Reference No:	2025/65/90113/E
Site Address:	Providence Place, Bradford Road, Cleckheaton, BD19 3PN
Description:	Listed Building Consent for internal and external alterations
Recommending Officer:	Edward Cheseldine

DECISION – GRANT LISTED BUILDING CONSENT

2025/90113 - Providence Place, Bradford Road, Cleckheaton, BD19 3PN

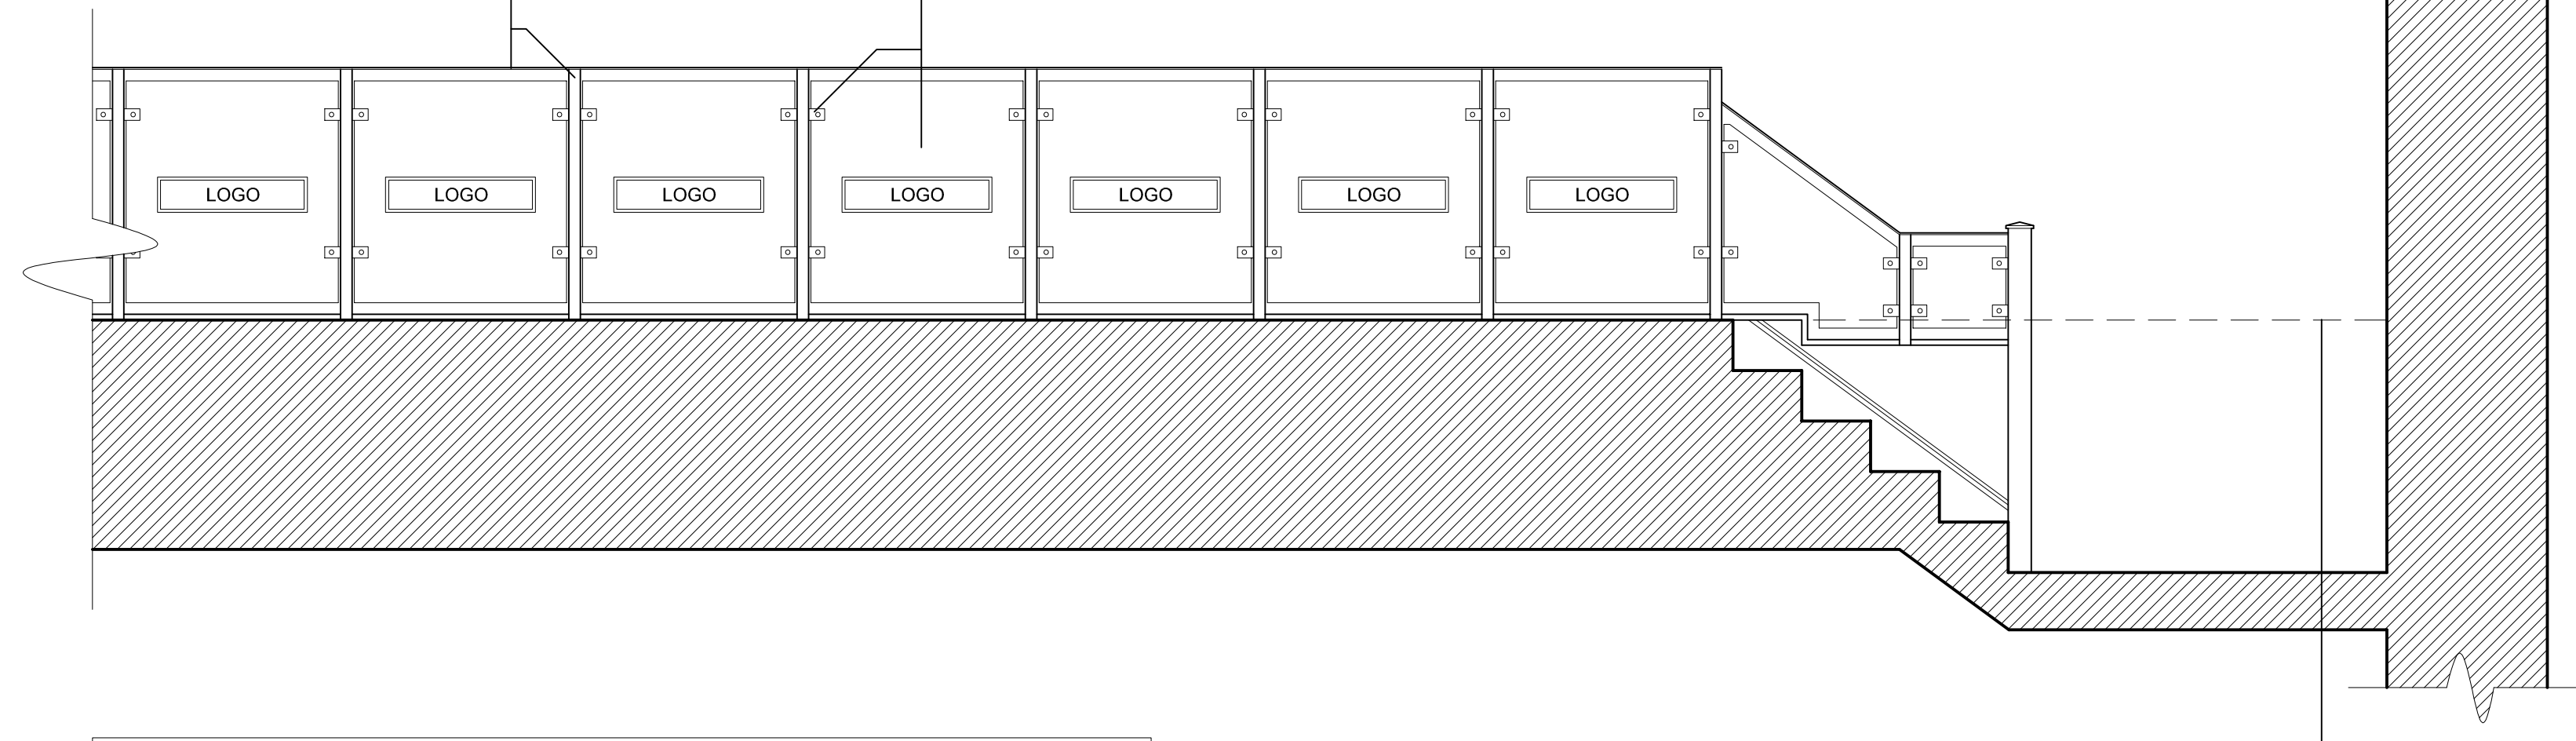
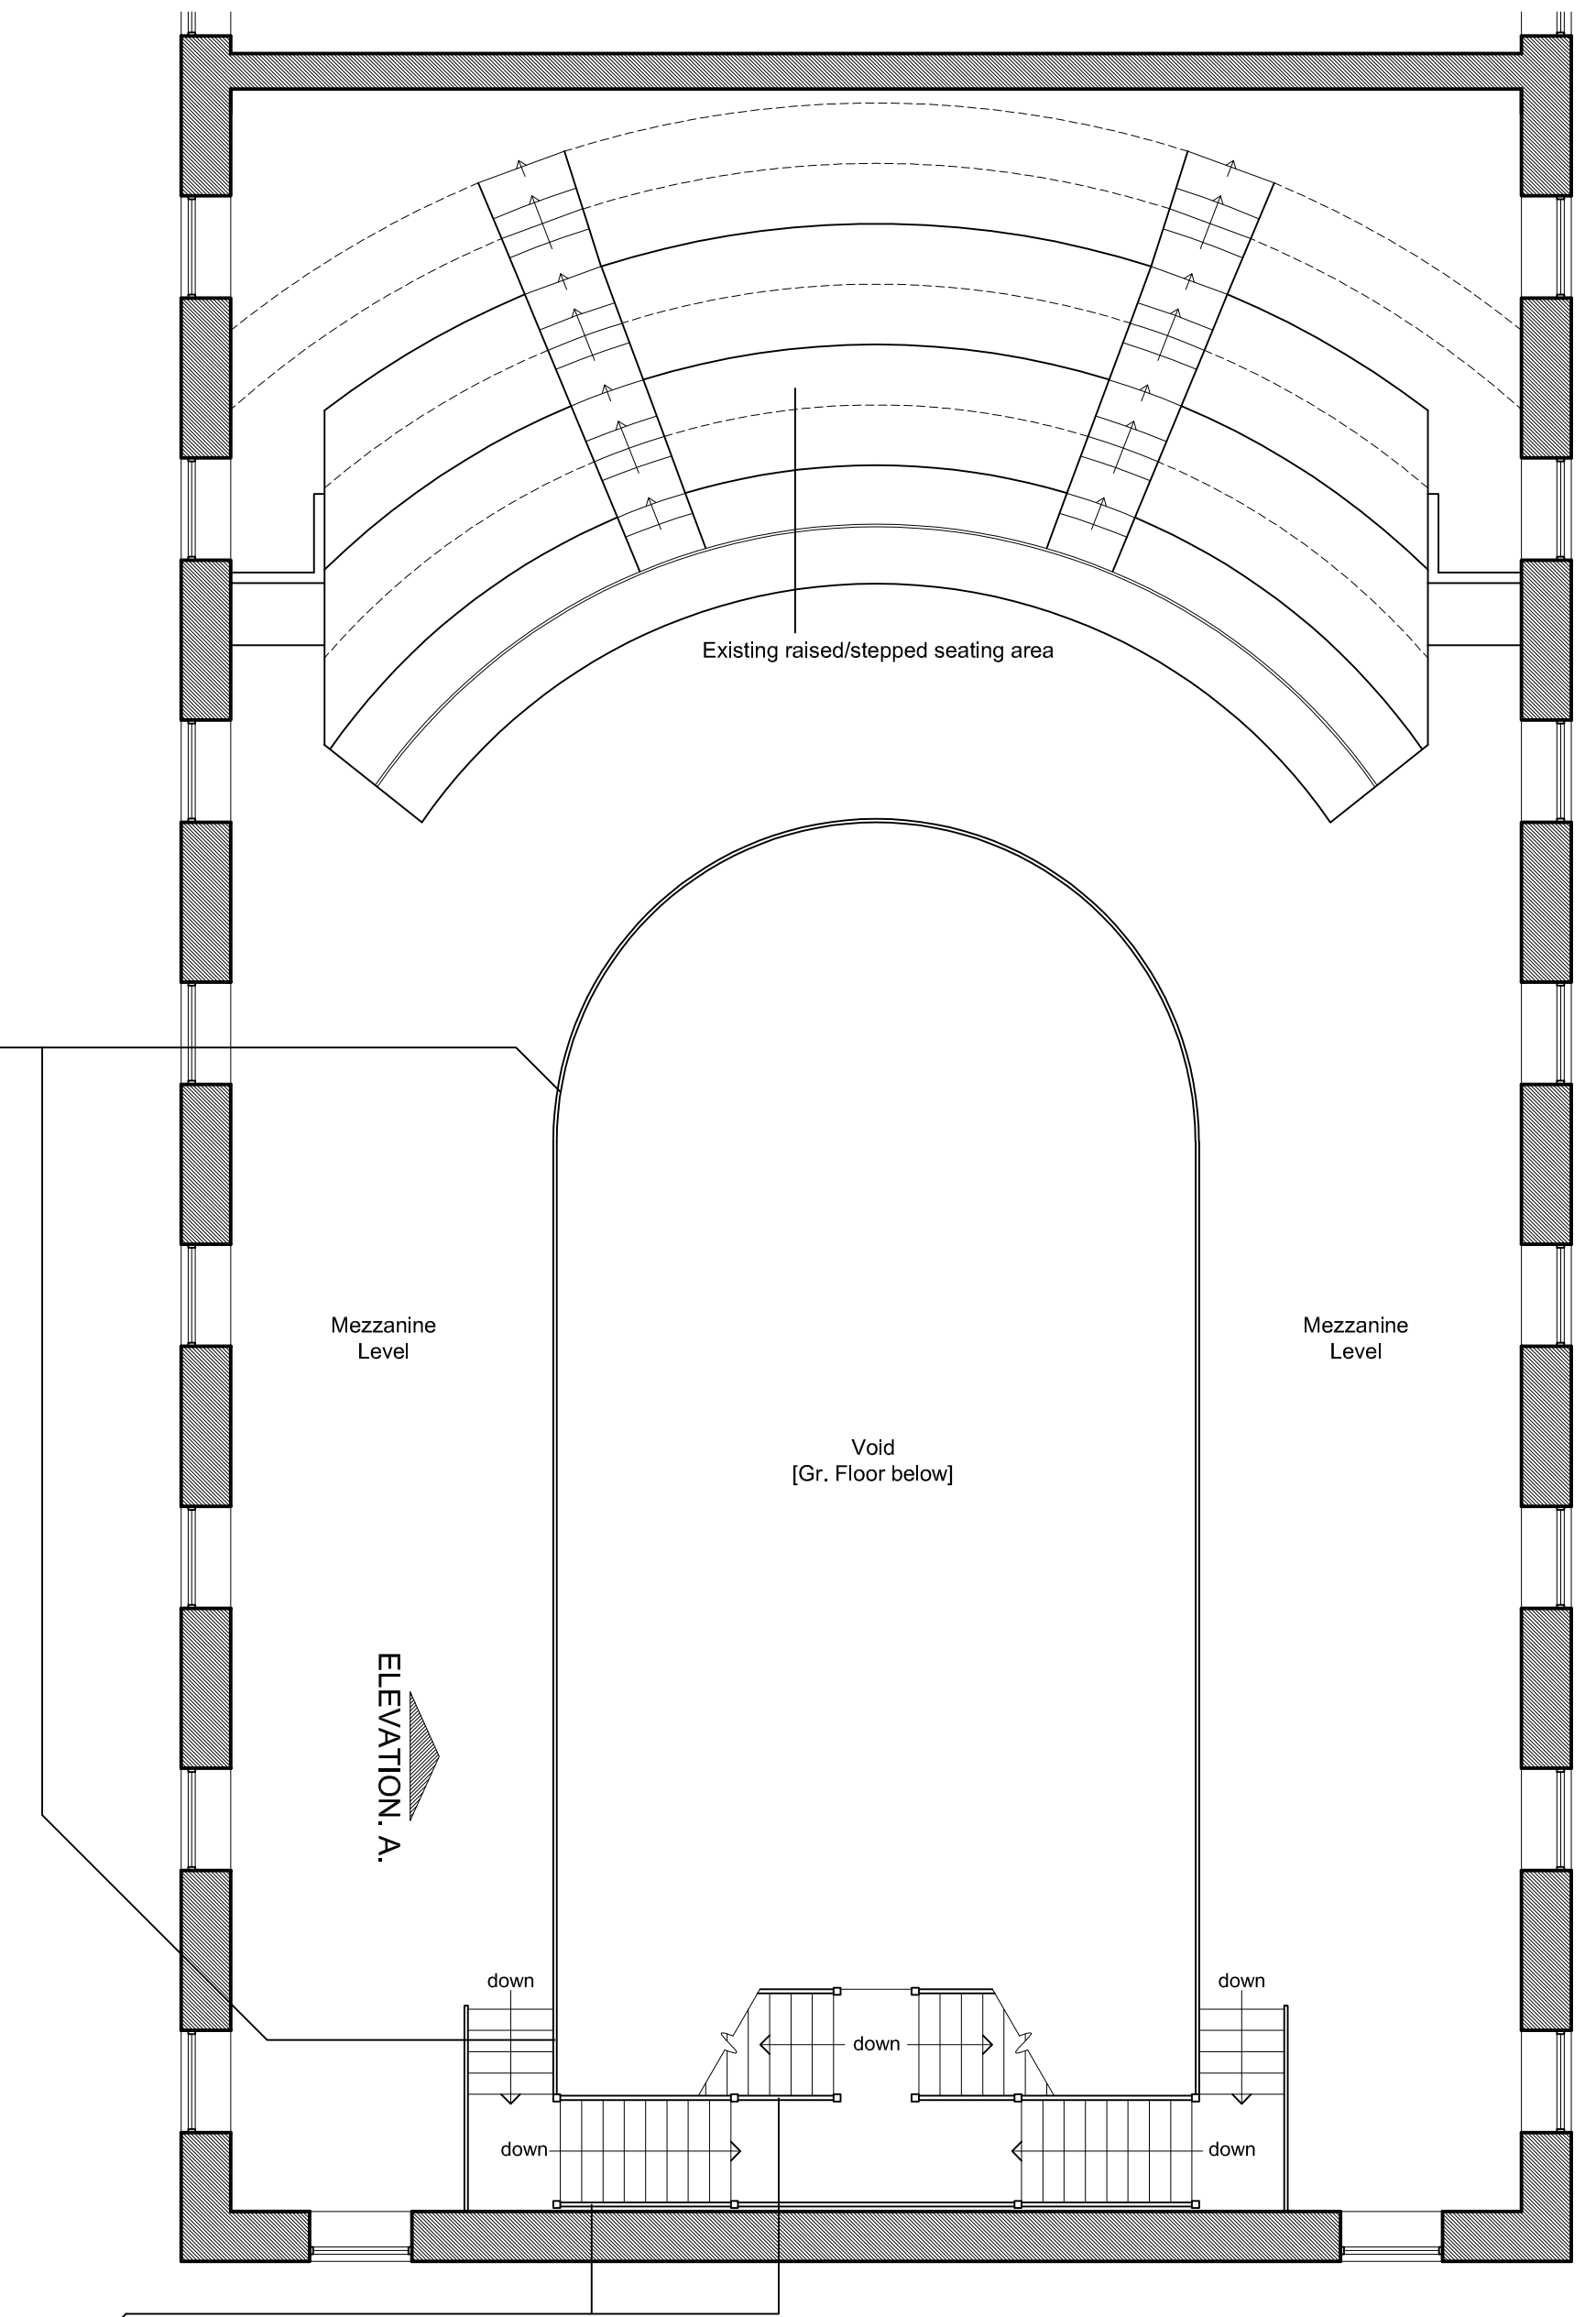
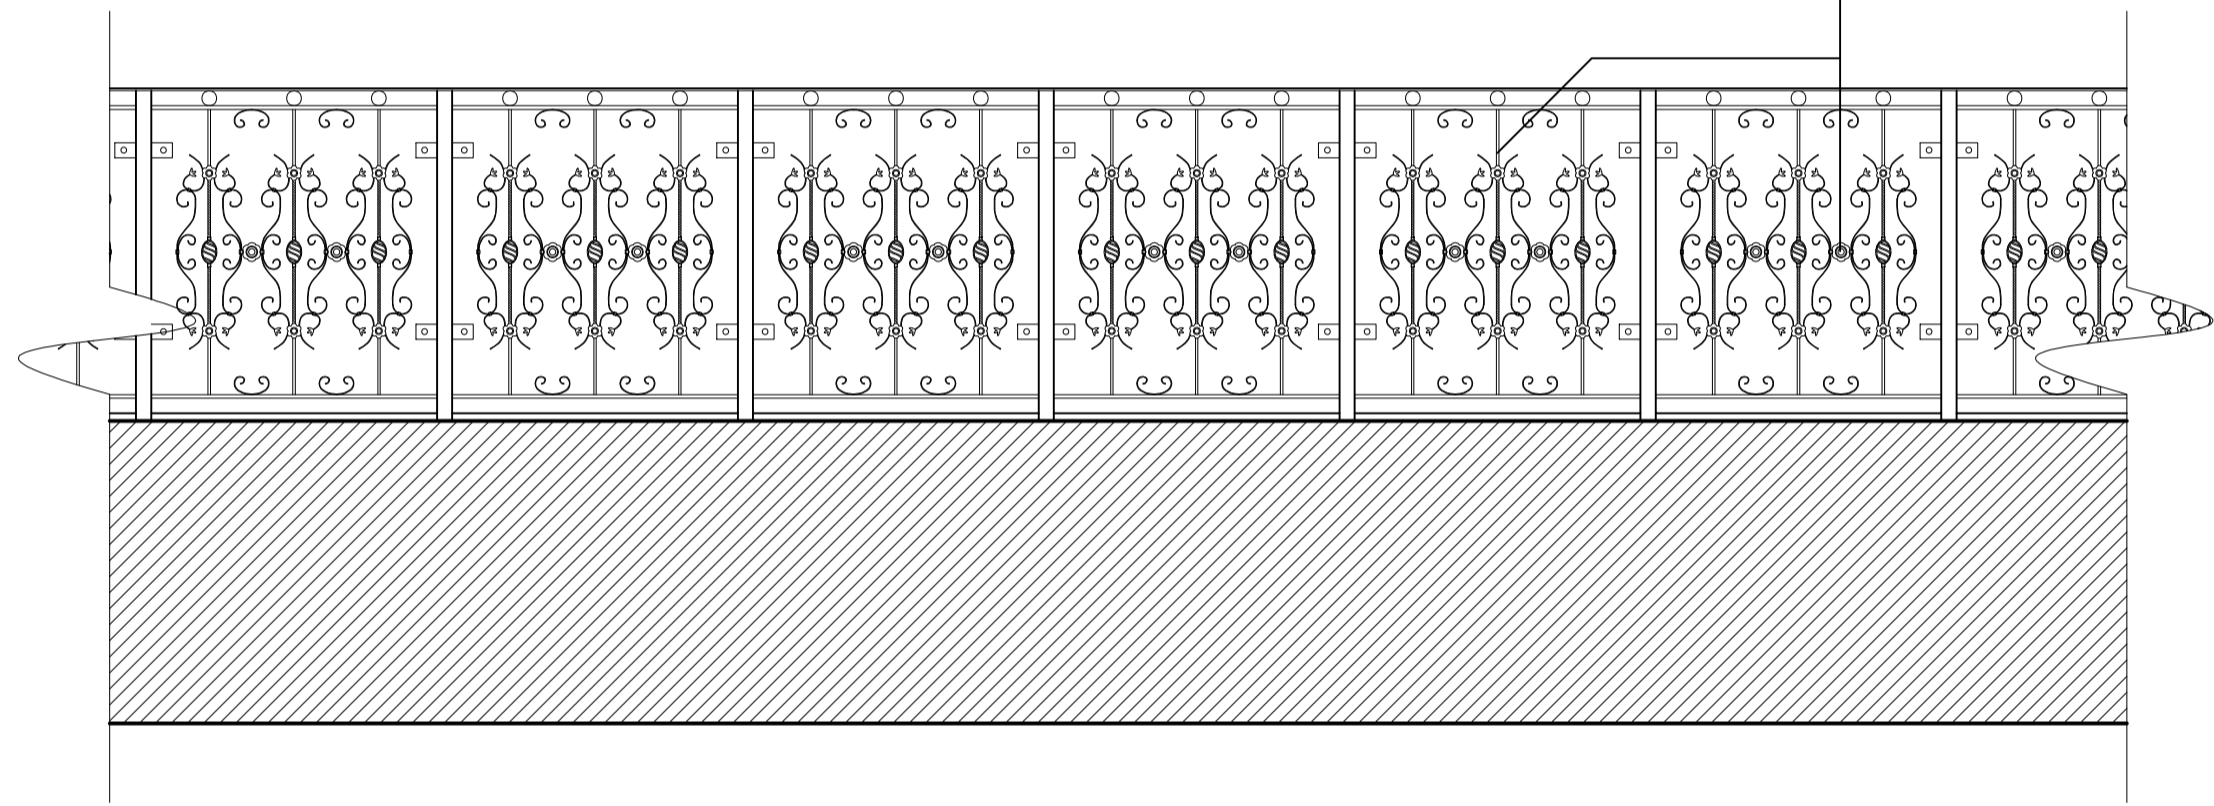
- Change of details of internal decorative balustrade as plans did not accord with materials on site.

Existing balustrades are glazed panels with metal handrails. Replacements are appropriate for the decorative hall, being iron with a period design. Finished in a black gloss. The panels will be fixed by new bars. Existing handrail will be reused. The alteration is appropriate to compliment the internal furnishings and details.
